Householder Application for Planning Permission for works or extension to a dwelling.  
Town and Country Planning Act 1990

Details of the pre-application advice received

Proposed GF Plans 1:50

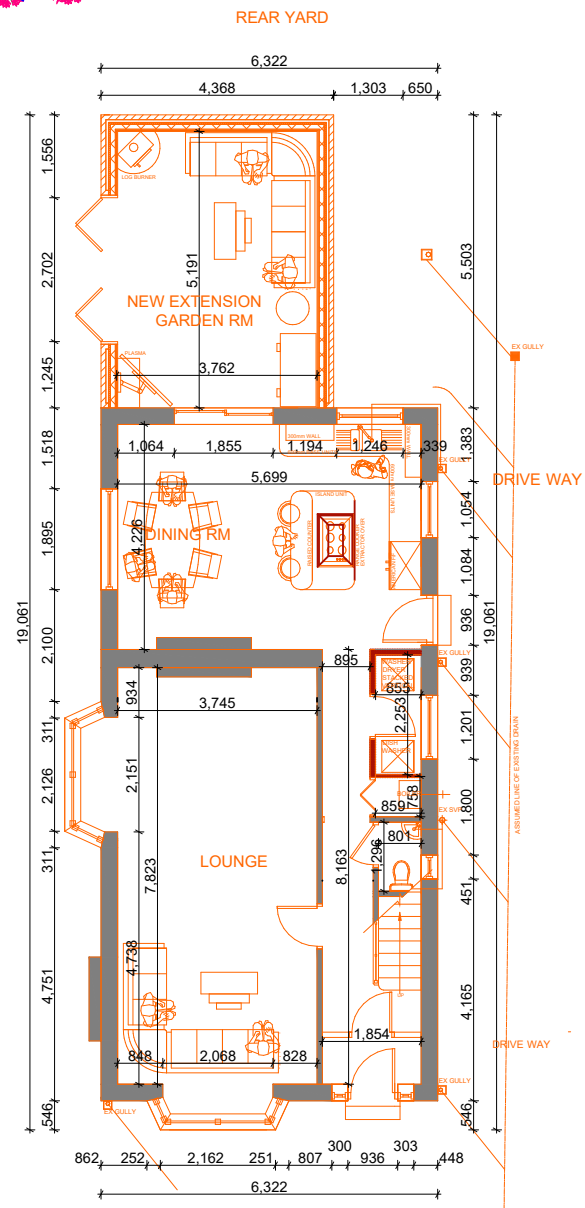
The ground floor extension projects more than the Councils SPD allows, however, as this is set away from 4 Albany Avenue and not seen due to the 2 garages it is unlikely to have an impact on their amenity. There are no windows proposed facing 89 Stony Hill Avenue and is set off the boundary so it would be unlikely to have any impact on their amenity.

The ground floor extension would be on the same footprint as the existing conservatory. The roof gable should be altered to be hipped though to match the line of the main dwelling roof. The principle of bifold doors to the Stony Hill Avenue is acceptable and the use of matching materials is acceptable.

Proposed FF Plans 1:50

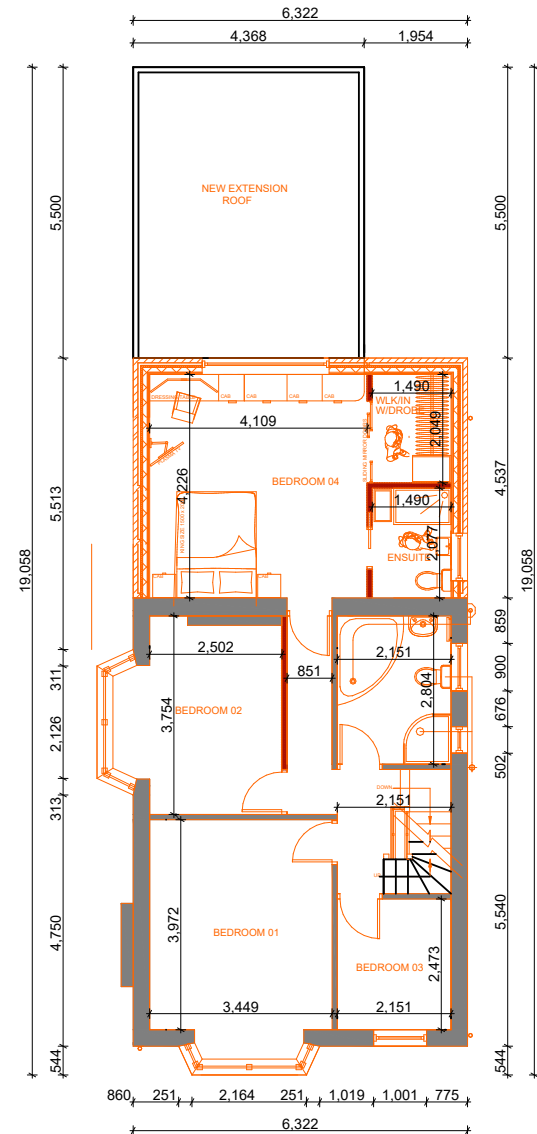
The first floor extension is set 6m away from 4 Albany Avenue this accords with the Councils SPD at 1.5m projection plus half the set off distance. There is a window facing 4 Albany however, it is obscure glazed. The extension would be set approx. 11m from 89 Stony Hill Avenue and the window to the rear elevation would need to be amended or this may have an impact on the amenity of 89 Stony Hill Avenue.

The first floor accords with the SPD in terms of projection, the eaves is set below the existing eaves and the ridge is set down from the main roof. The roof gable should be altered to be hipped though to match the line of the main dwelling roof. The use of matching materials is acceptable.

Proposed roof Plans 1:50

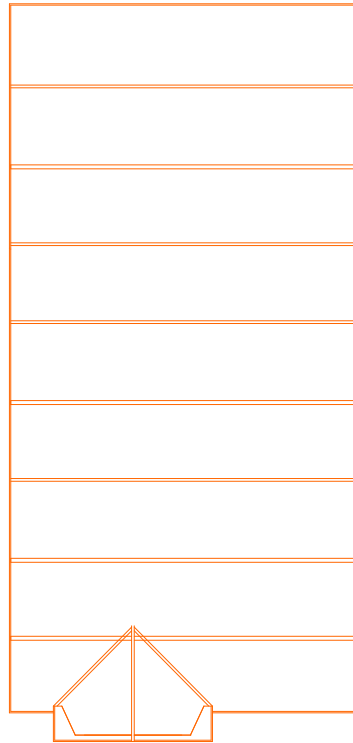
As mentioned previously to the applicant, the roof space proposal should be reconsidered. The roof extension should be deleted and the applicant should look at doing something internally within the roof space and possibly velux windows. The impact of another addition within this prominent location would have a significant impact on the property and the street scene and is therefore not supported.
